Your Ref: Inet 000011085
Our Ref: P/49/11/
Please ask for:
Mrs J Chapman

The Town and Country Planning Act 1990 (as amended)

Raised decking to the rear of the bungalow.
94 Harbour Road Bognor Regis

Drawing 02
June 2011

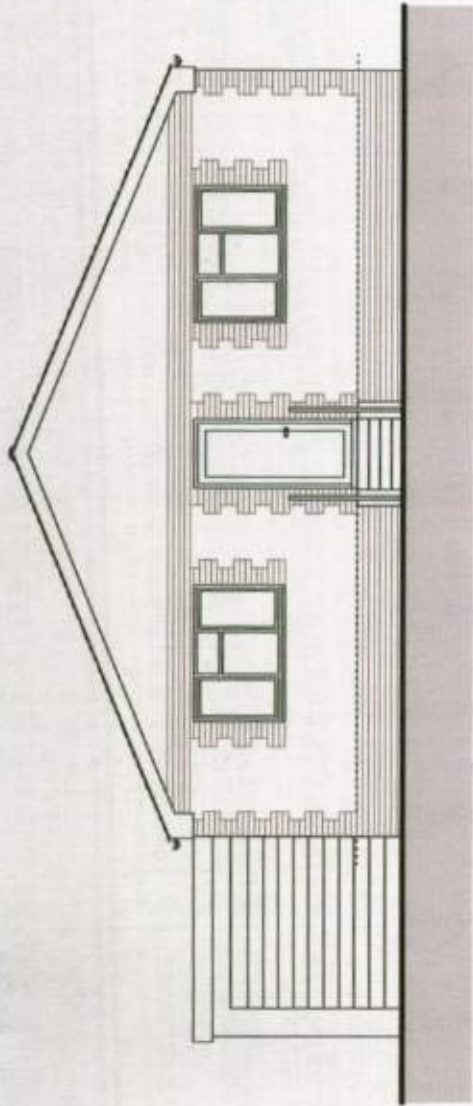
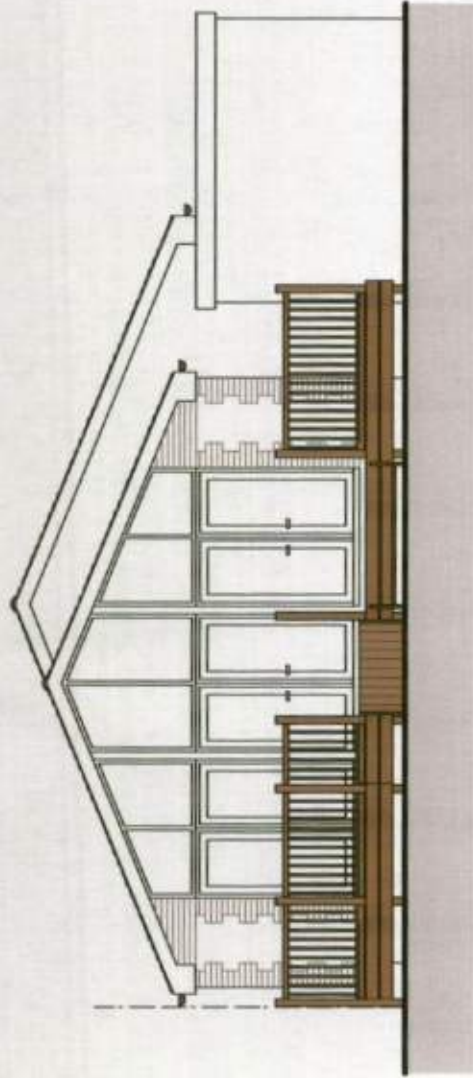
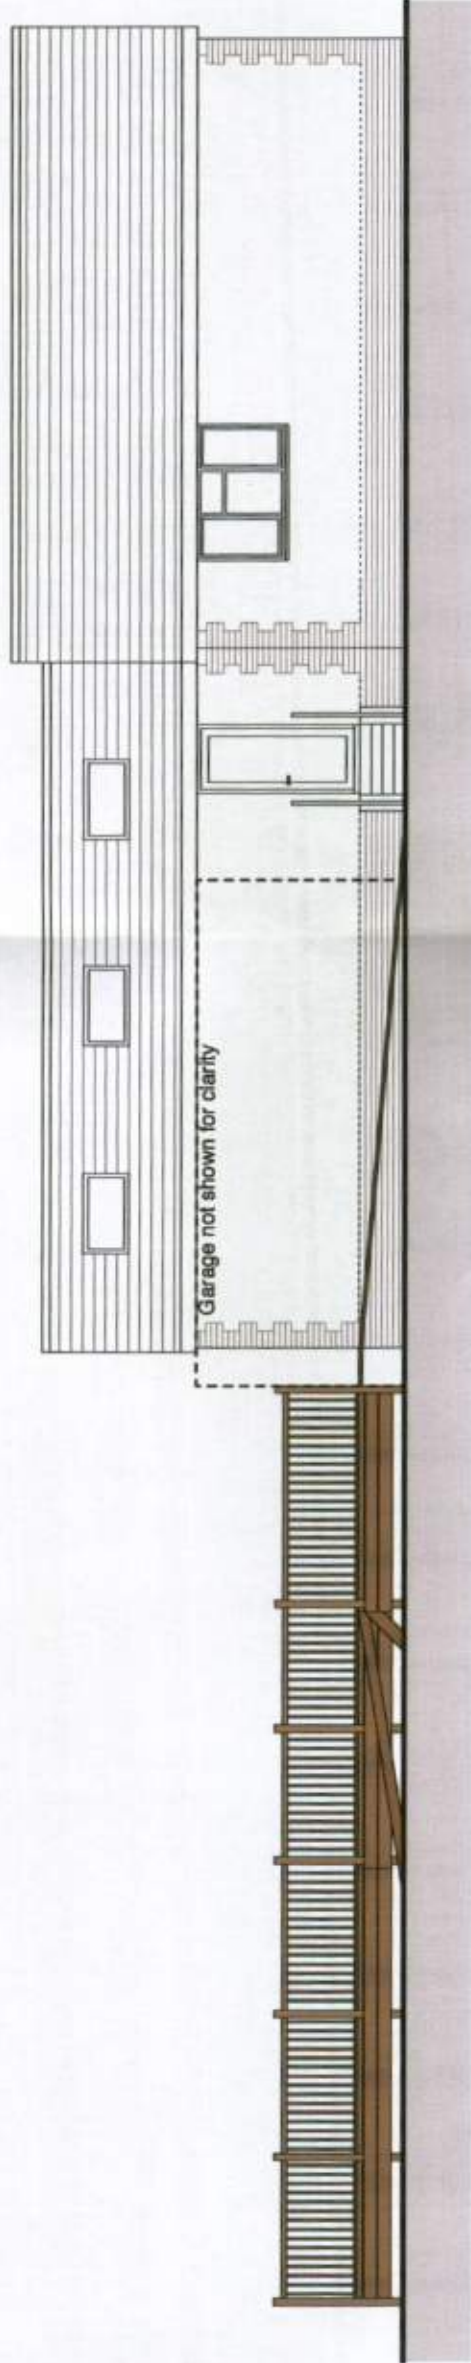
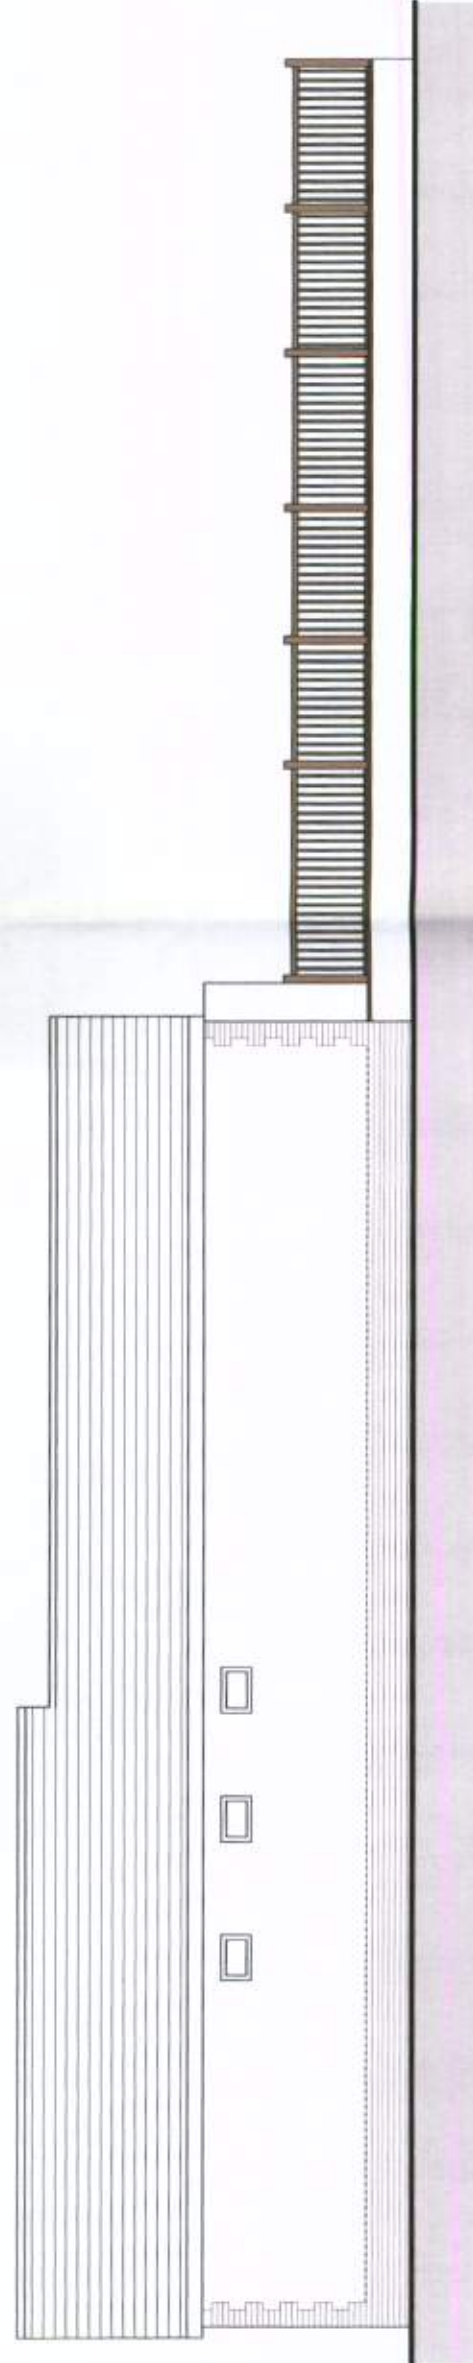
Is this a retrospective application? The raised decking is already in existence and has been for some time. I do not recall seeing a planning application notice for this at the time of its erection. The decking is very much raised and the fencing is high accordingly. This is out of kilter with the properties in this row. The view from my garden is limited in that direction now. My property is a holiday let and it has been adversely affected and is overlooked by this construction.
